MMC St. John Employee Garage - LIII Site Plan Conditions of Approval Submittal for Issuance of Building Permit

Hi Nell – I have reviewed information provided by the Applicant in conjunction with Site Plan Conditions for Parking Garage Circulation and Provision of a Construction Management Plan for off-site roadway construction. My comments are noted below.

PHASE 1 LOGISTICS PLAN SEPTEMBER 2018 - SUMMER 2019

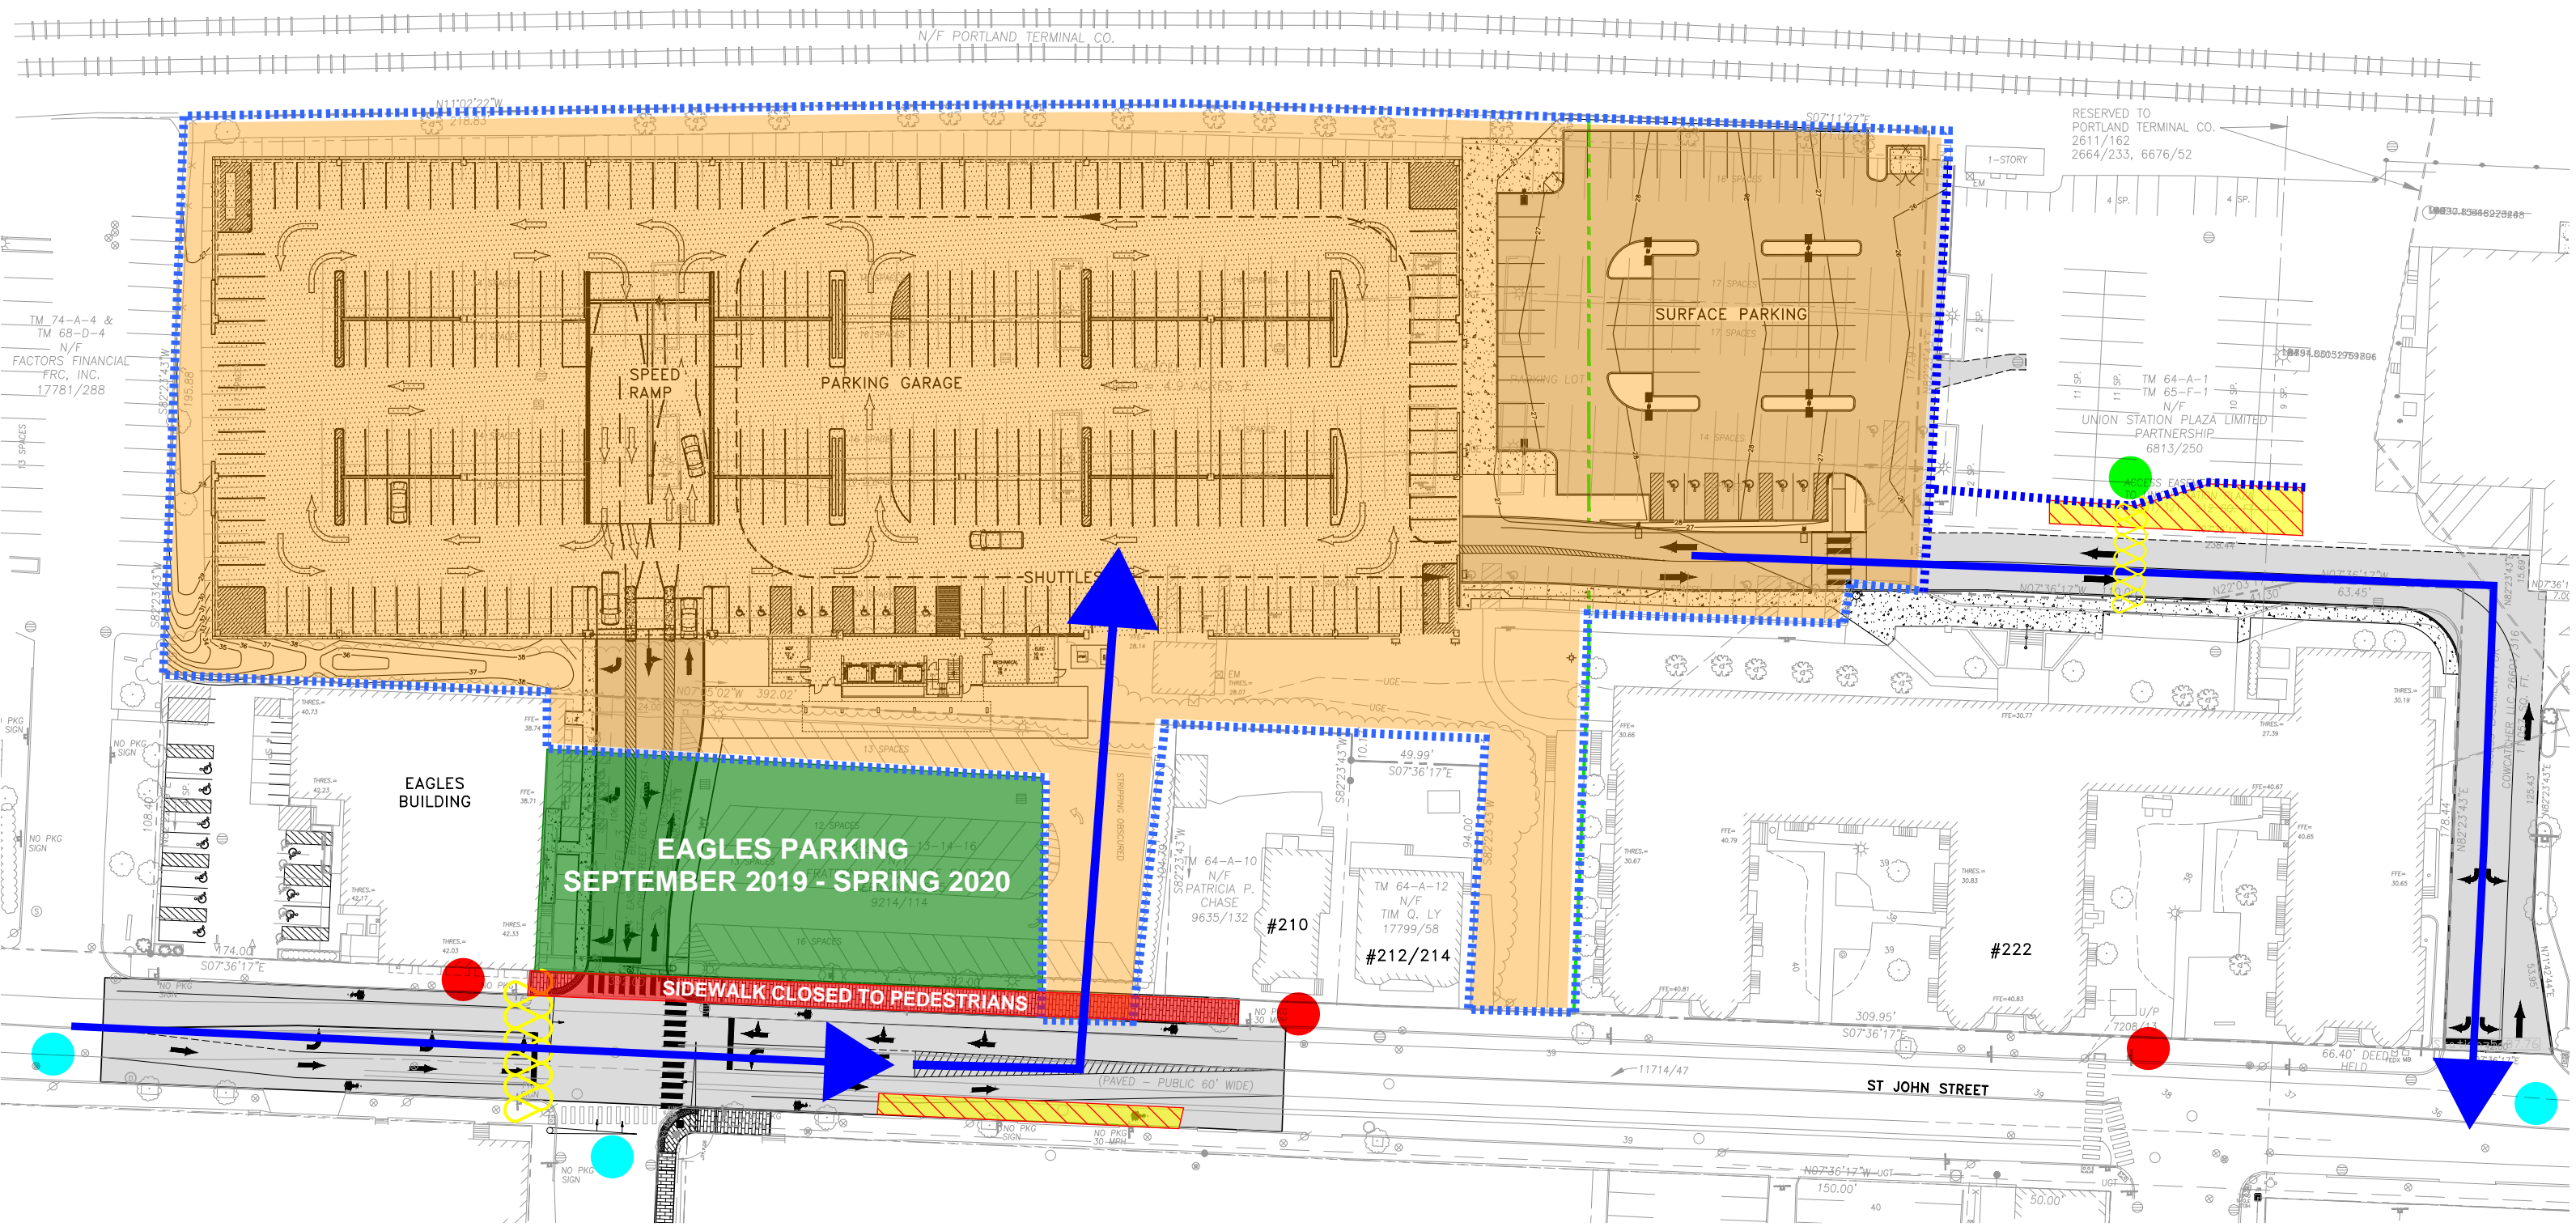
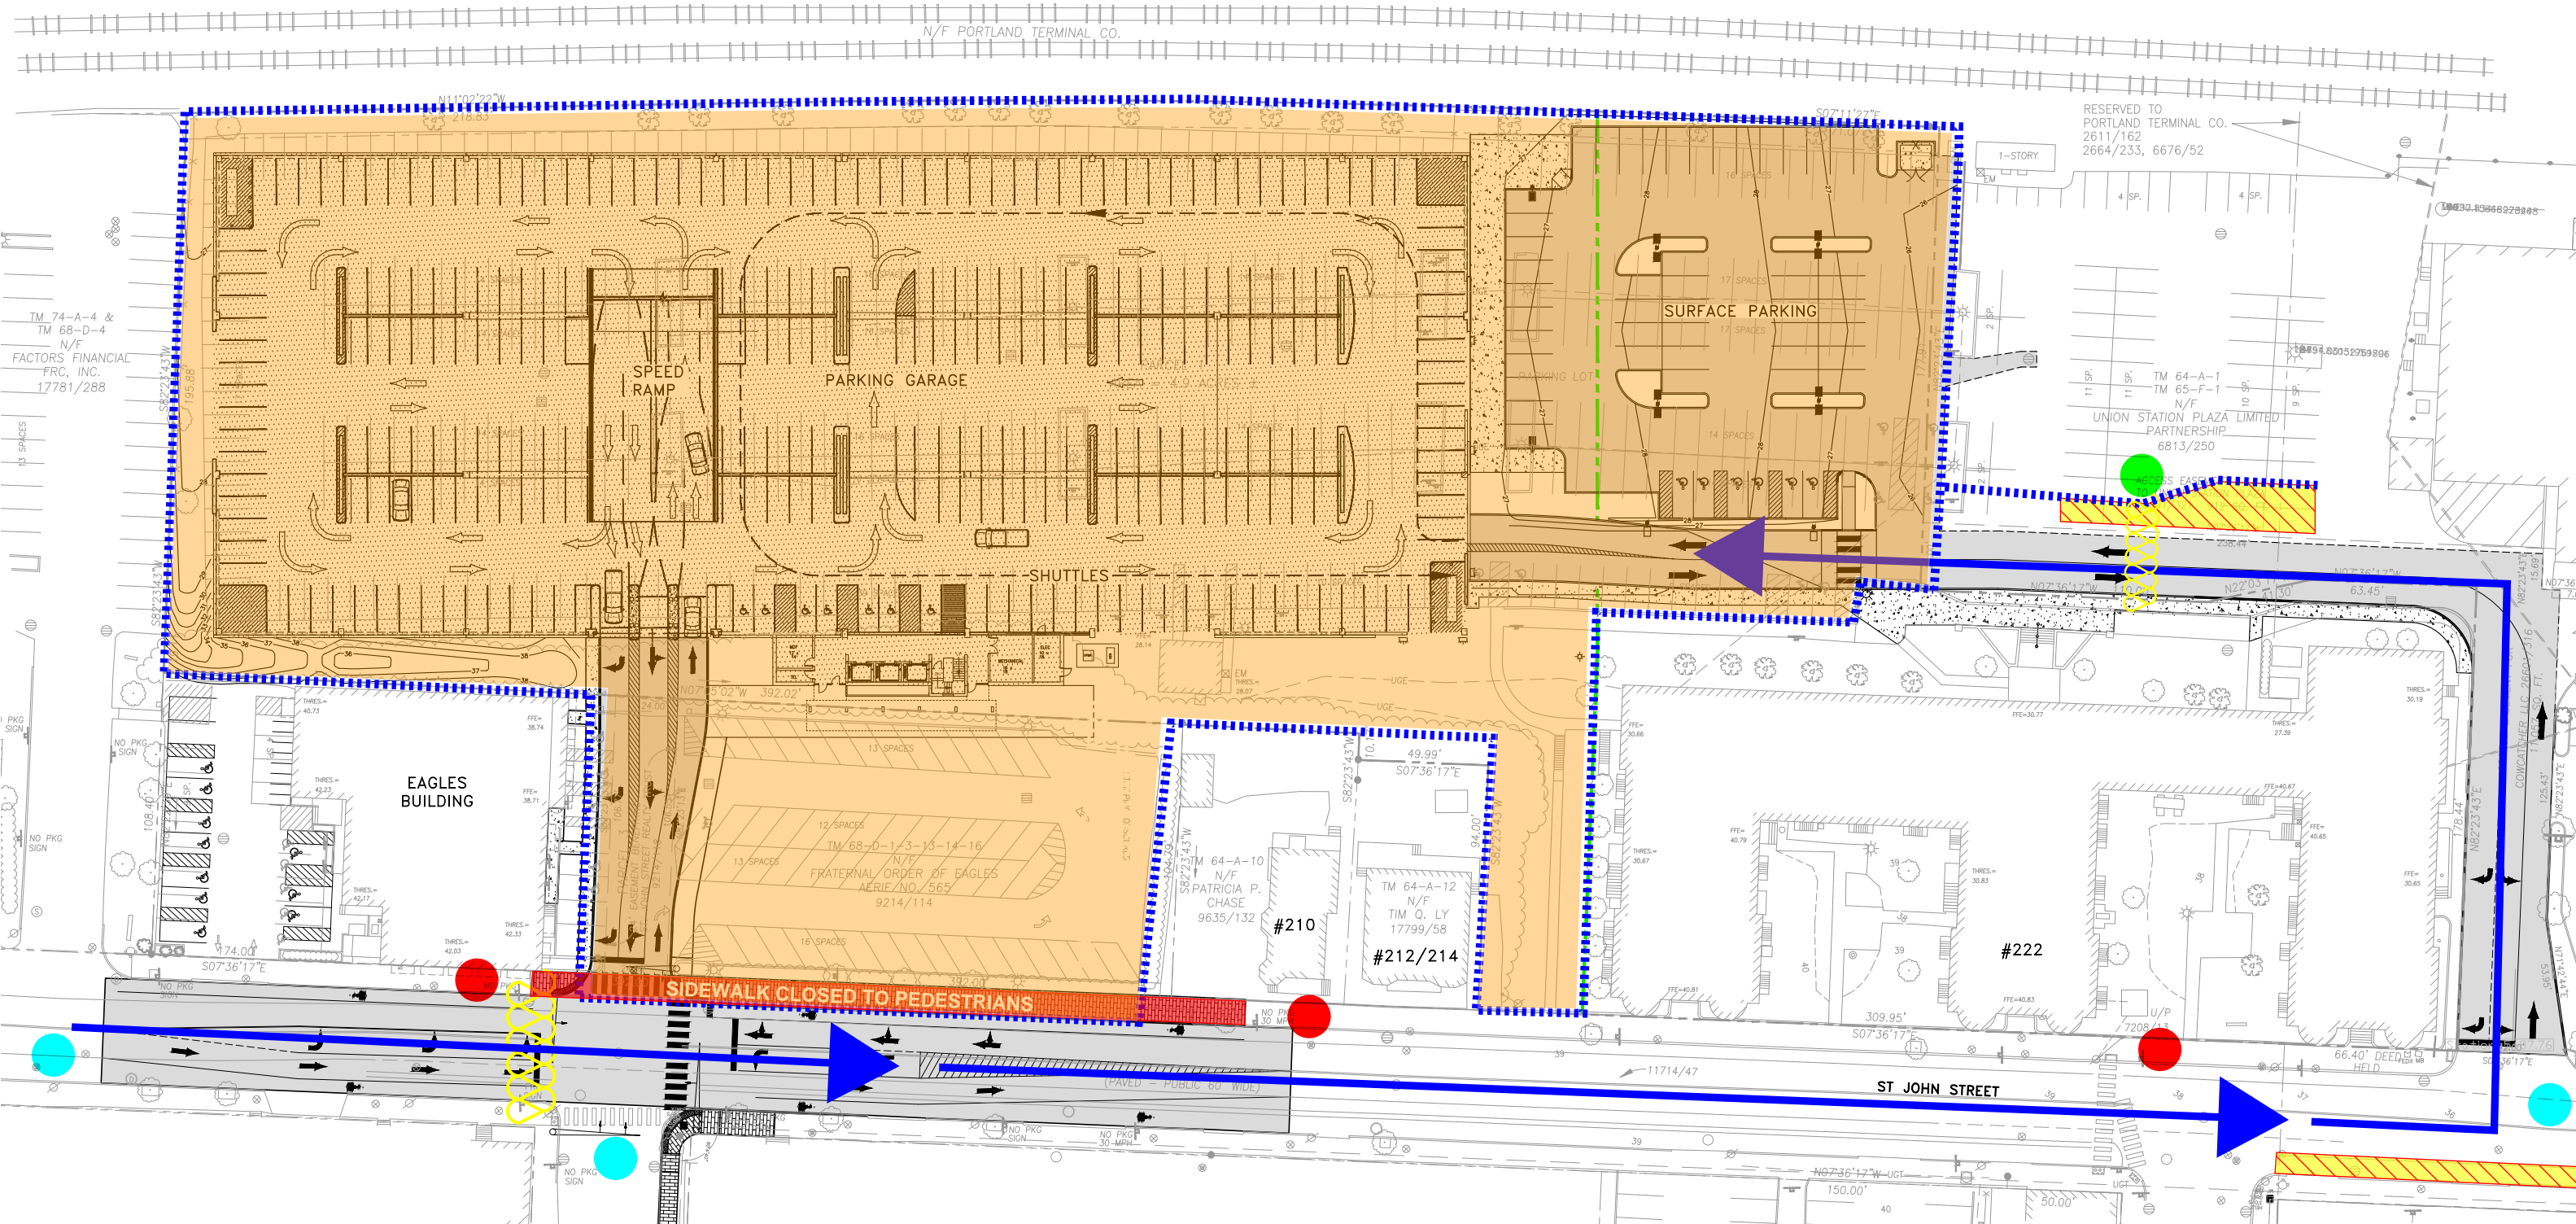
- I have reviewed the September 24, 2018 Memorandum prepared by VHB and their conclusion (*We believe that the current design and access/circulation configuration, coupled with key technology provisions, will support efficient entering and exiting maneuvers by MMC staff and will not impede traffic operations along St John Street*) seems reasonable and accordingly this condition has been met.
- The Applicant provided very general information as it relates to St. John Street, D Street, and Valley Street construction management plan details. I would suggest that greater detail be provided prior to the issuance of a City Street Opening Permit.
